# PLACE AND GROWTH INTERNAL MEMORANDUM

**Your Ref:** 21/03644/OUT

## APPLICATION FOR PLANNING PERMISSION PLANNING POLICY CONSULTATION RESPONSE

<b>Planning Application No.</b>	21/03644/OUT
<b>Address / Location</b>	OS Parcel 6372 South East Of Milestone Farm, Broughton Road, Banbury
<b>Proposal</b>	Erection of up to 49 dwellings, associated open space, sustainable urban drainage systems, and access from Balmoral Avenue
<b>Key Policies / Guidance</b>	<p><b>Cherwell Local Plan 2015</b> Policy SLE 4: Improved Transport &amp; Connections Policy BSC 1: District Wide Housing Distribution Policy BSC 3: Affordable Housing Policy BSC 4: Housing Mix Policy BSC 10: Open space, Outdoor Sport &amp; Recreation Provision Policy BSC 11: Local standards of Provision – Outdoor Recreation Policy BSC 12: Indoor Sport, Recreation &amp; Community Facilities Policies ESD 1 – 5 Mitigating &amp; Adapting to Climate Change Policy ESD 7: Sustainable Drainage Systems Policy ESD 10: Protection and Enhancement of Biodiversity and the Natural Environment Policy ESD 13: Local Landscape Protection &amp; Enhancement Policy ESD 15: The Character of the Built and Historic Environment Policy ESD 17: Green Infrastruc

Figure 16: Zone of Theoretical Visibility, Zone of Visual Influence and Viewpoints Assessed

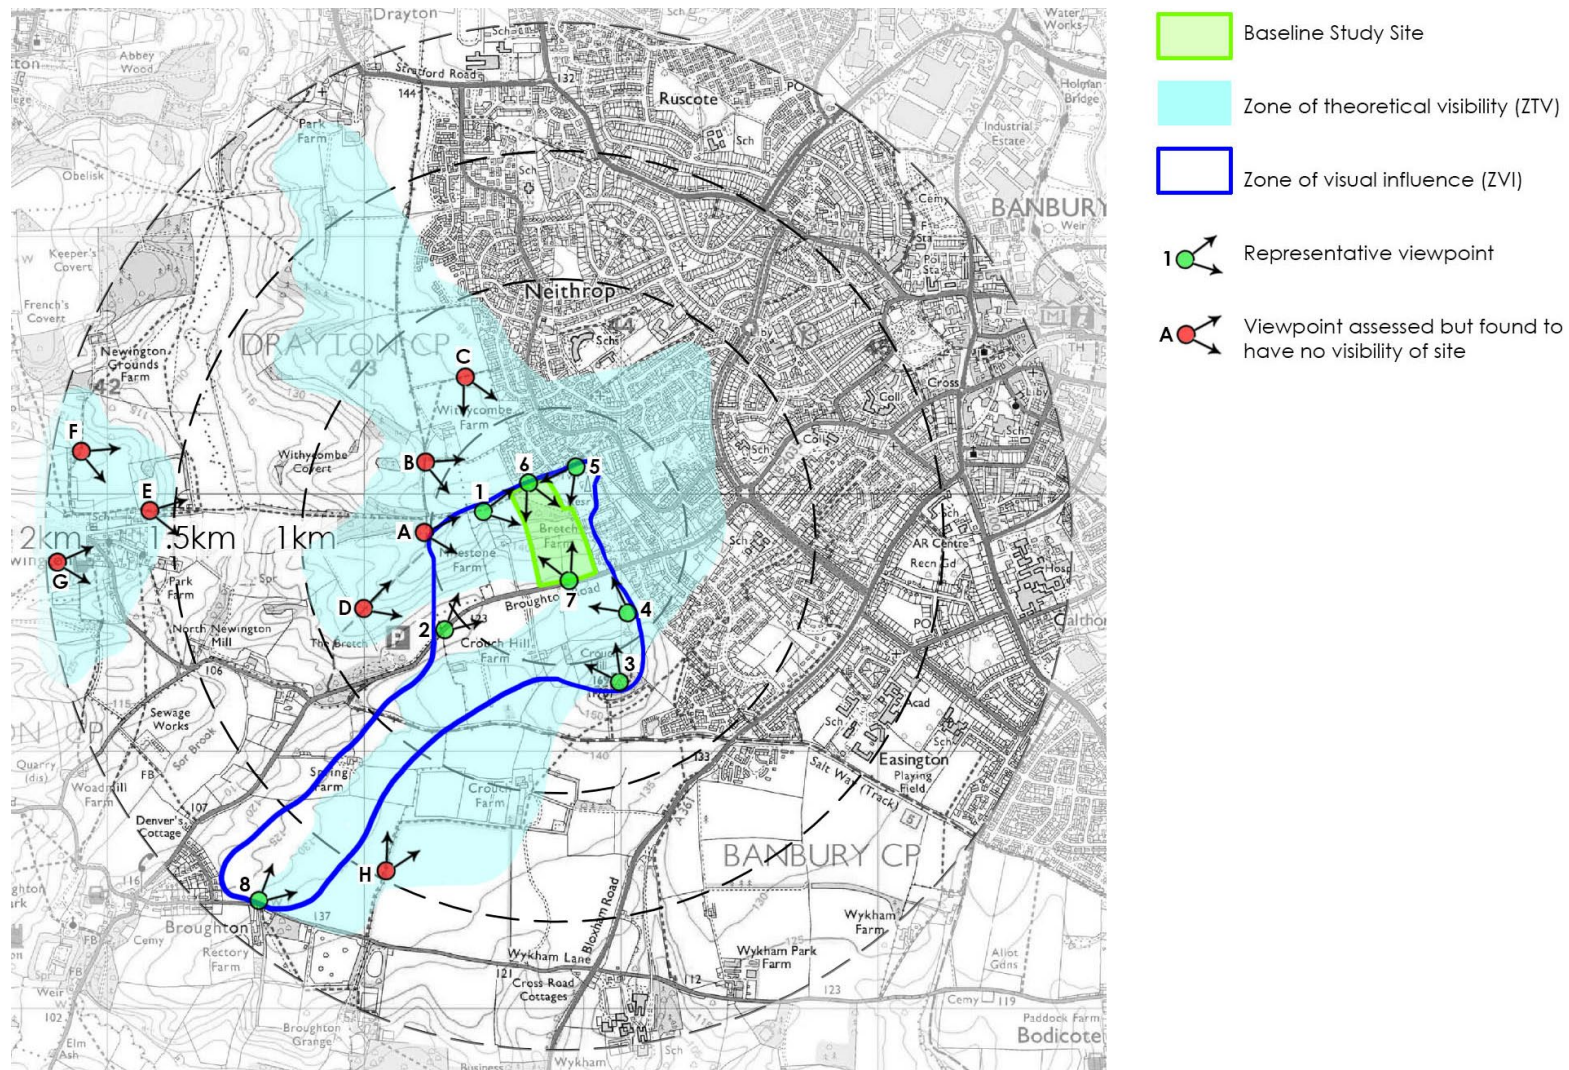
- It is noted that the LVIA submitted in support of the application indicates that the site will be visible from the Broughton Road, when approaching from the west. The LVIA also states that the site will be visible from Crouch Hill, which the local plan identifies as an important local landscape feature. The photograph on page 22 would indicate that the development will clearly be visible as an extension into open countryside.

- It is noted that although residential development is not proposed in the fields adjacent to Broughton Road, extensive engineering operations are. The impact of these engineering operations on the landscape character of the locality should also be assessed.
